CITY OF ALBUQUERQUE

**Re: Santa Fe Federal Credit Union, 7101 Jefferson Street NE, Grading and
Drainage Plan, Engineer's Stamp dated 06-04-2013 (D-17/D017)**

Based upon the information provided in your submittal received 06-06-13, the above referenced plan cannot be approved for Building Permit until the following comments are addressed:

Detail

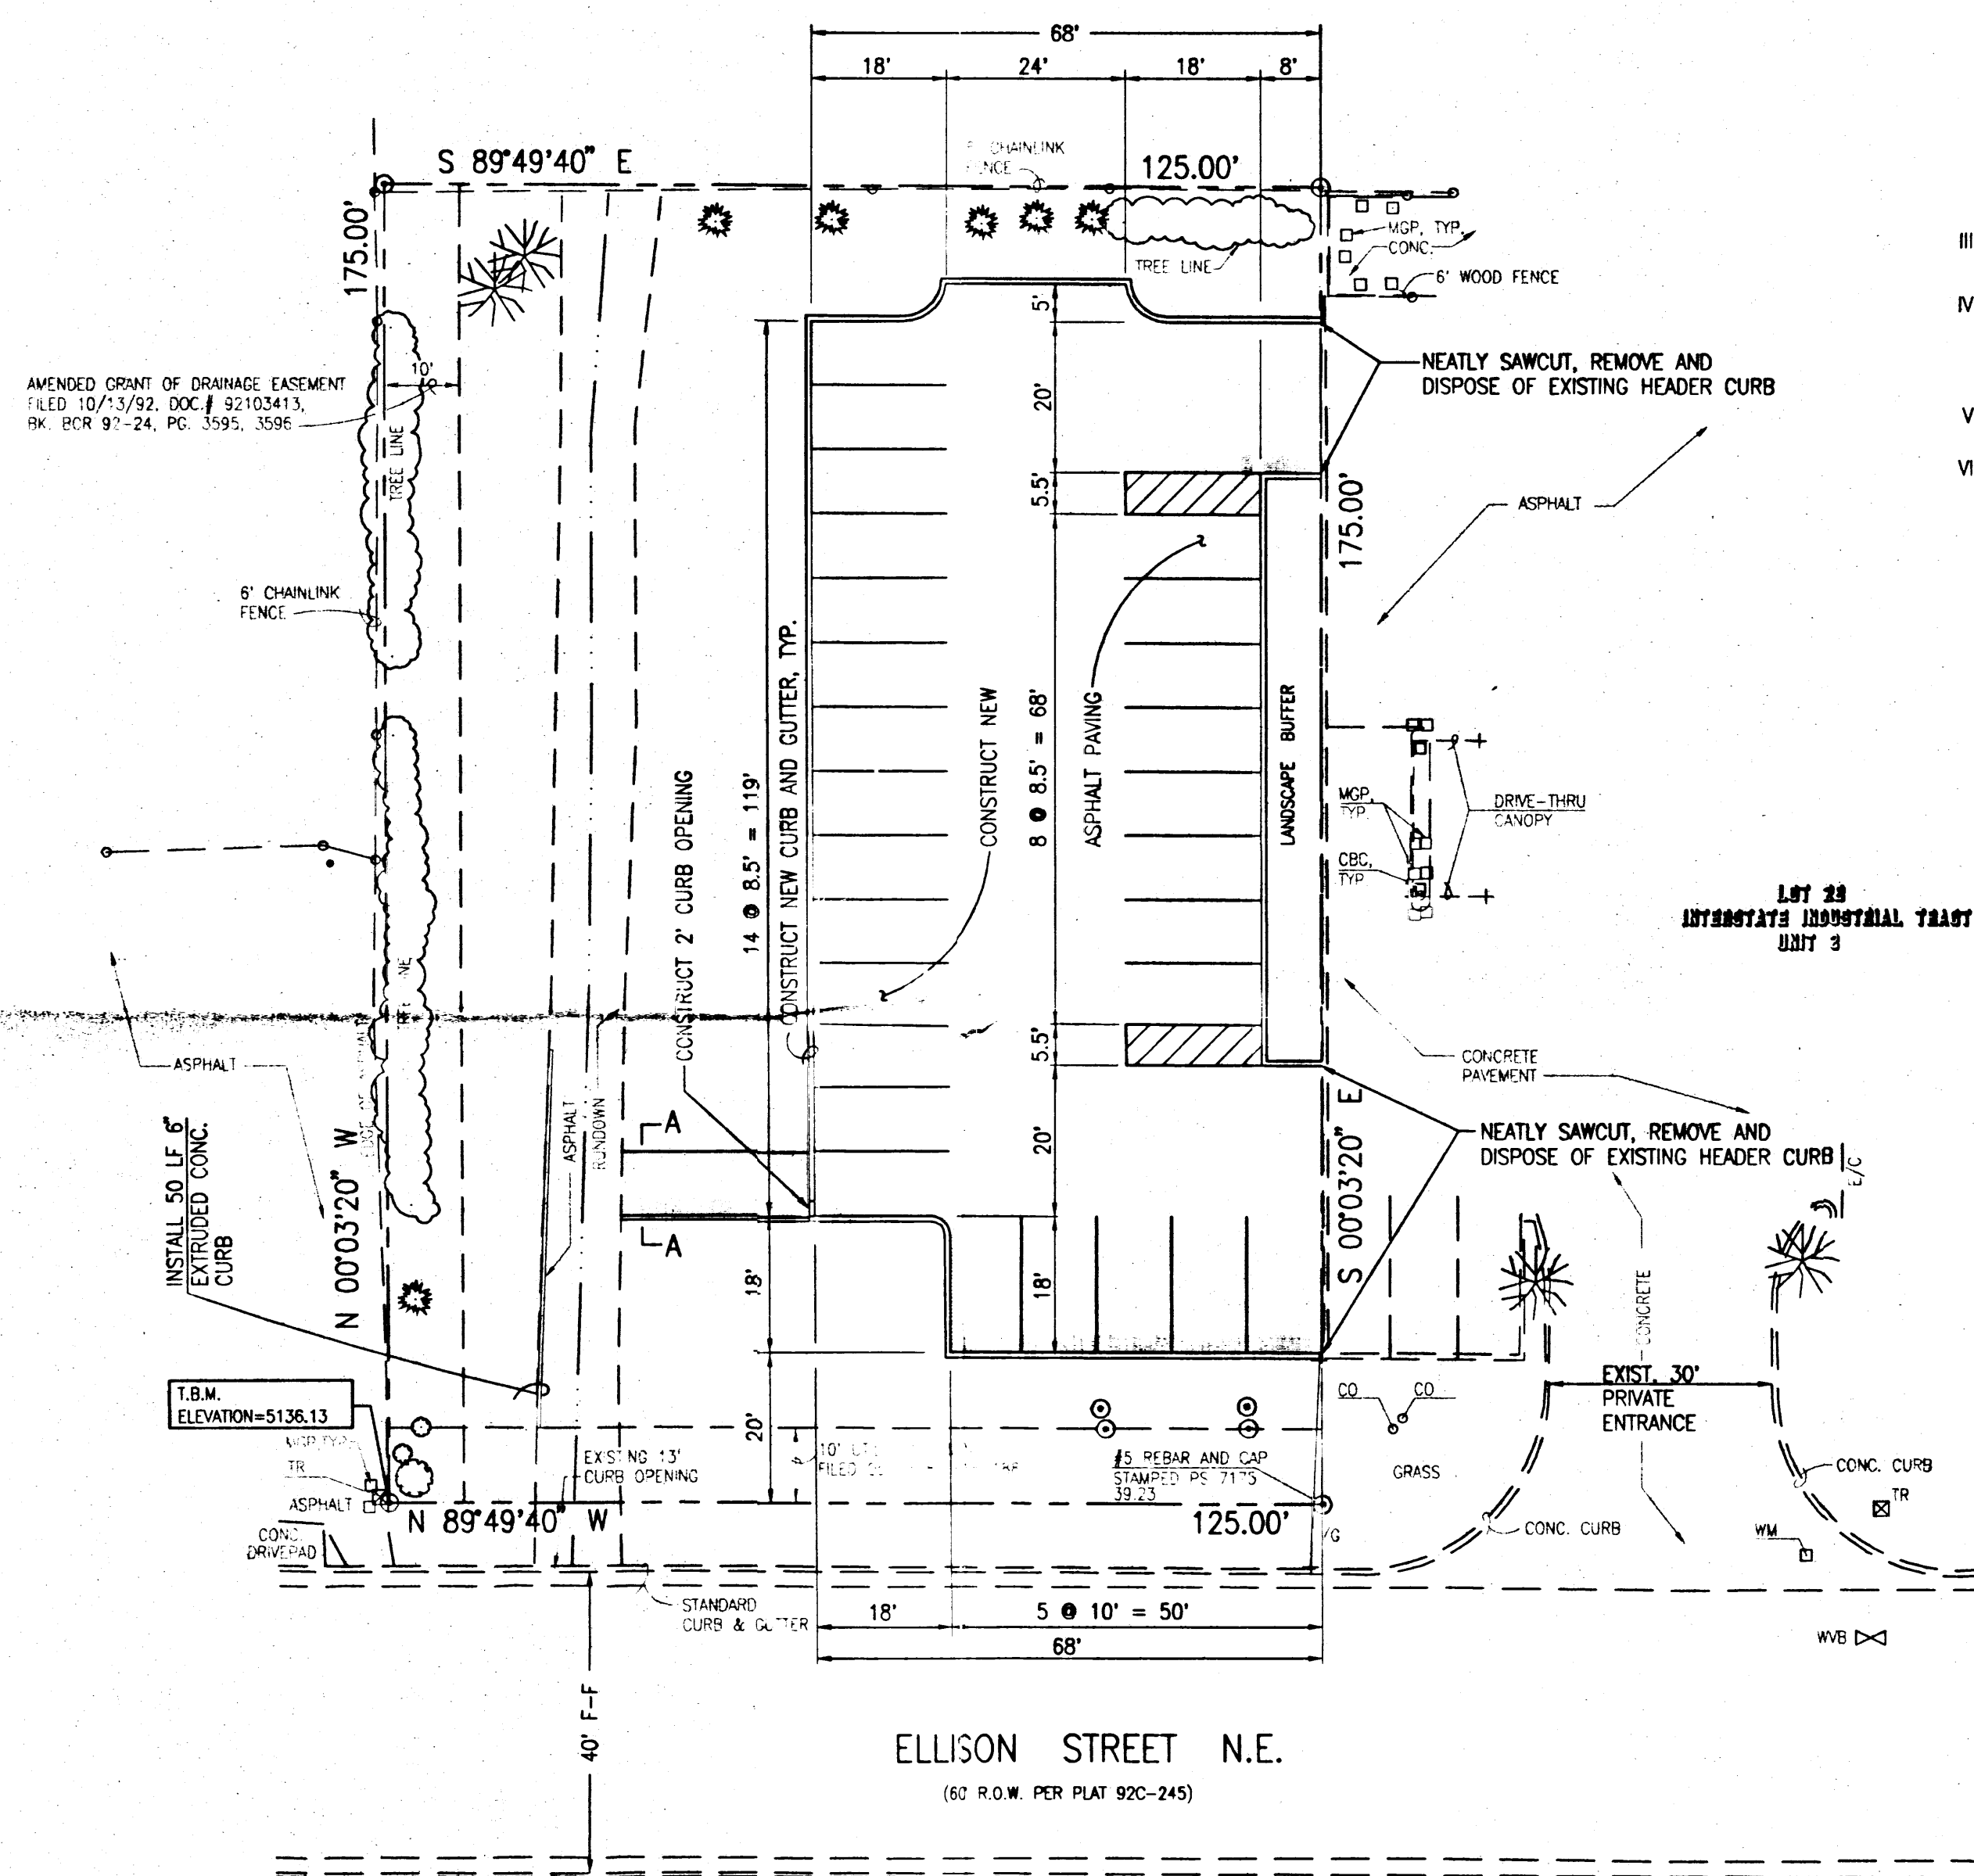
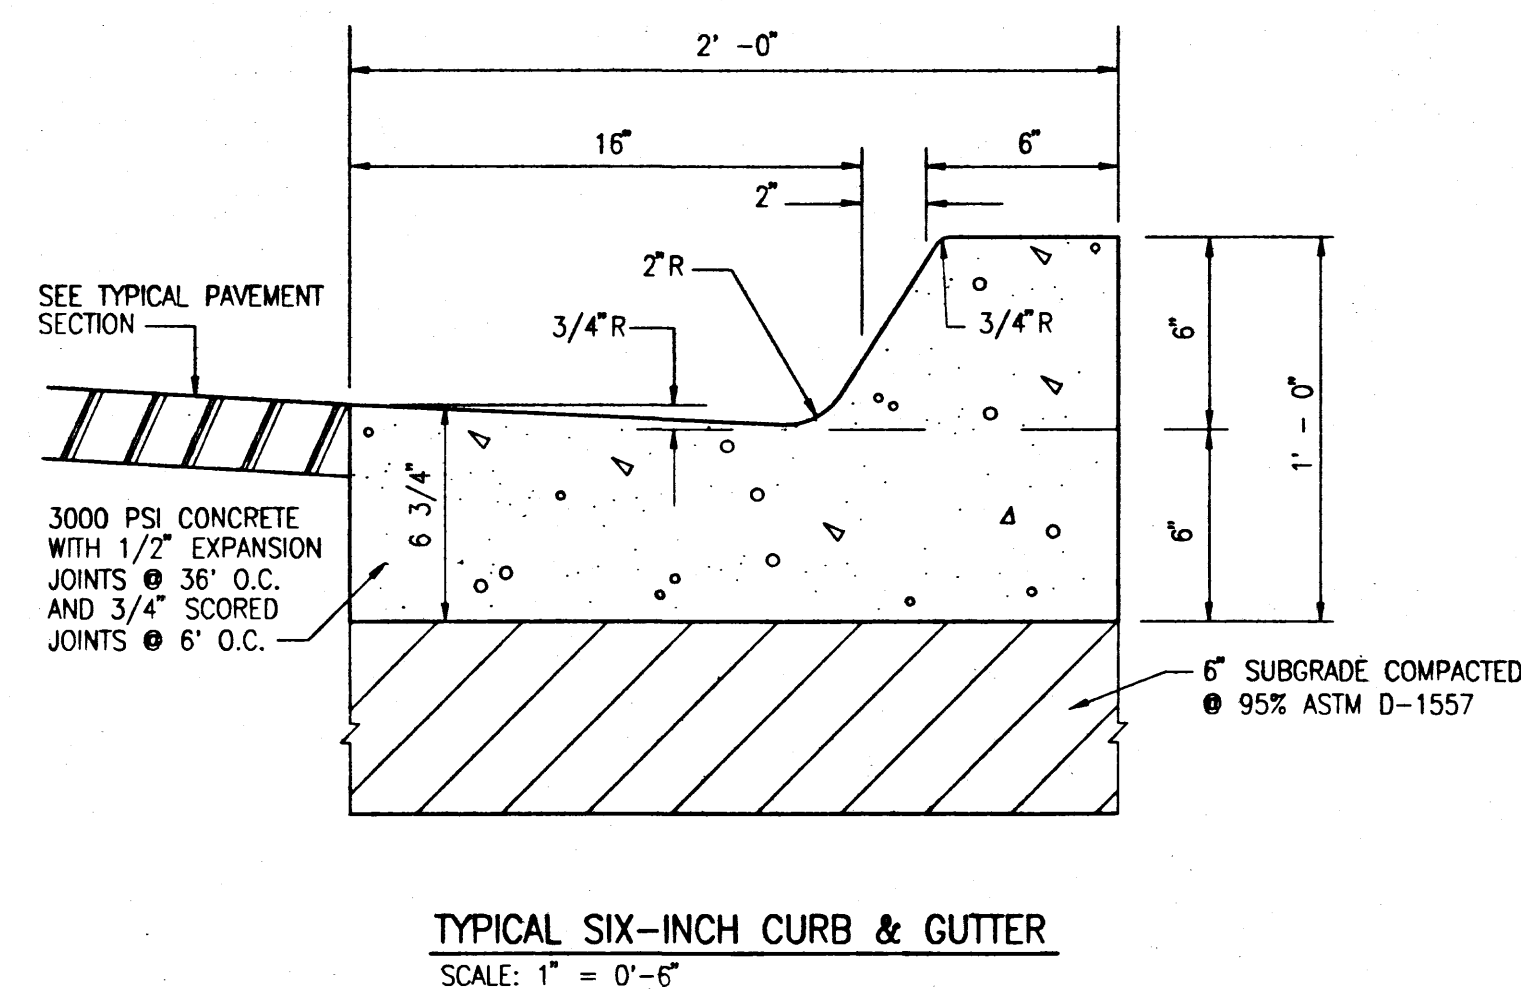
- Please quantify the offsite flows from the parking lot to the north of your project and include these flows in the drainage calculations for the existing sidewalk culvert; if over capacity address how these flows will be accommodated.
- Add a note to extend the culvert and culvert plate two feet back from the property line and to tack weld the bolts to the steel plate.
- Clarify if the existing swale is completely asphalt lined. Satellite imagery shows a significant amount of sediment in this channel.
- If the sidewalk culvert is altered please provide both an invert elevation and flowline elevations within Ellison Street.
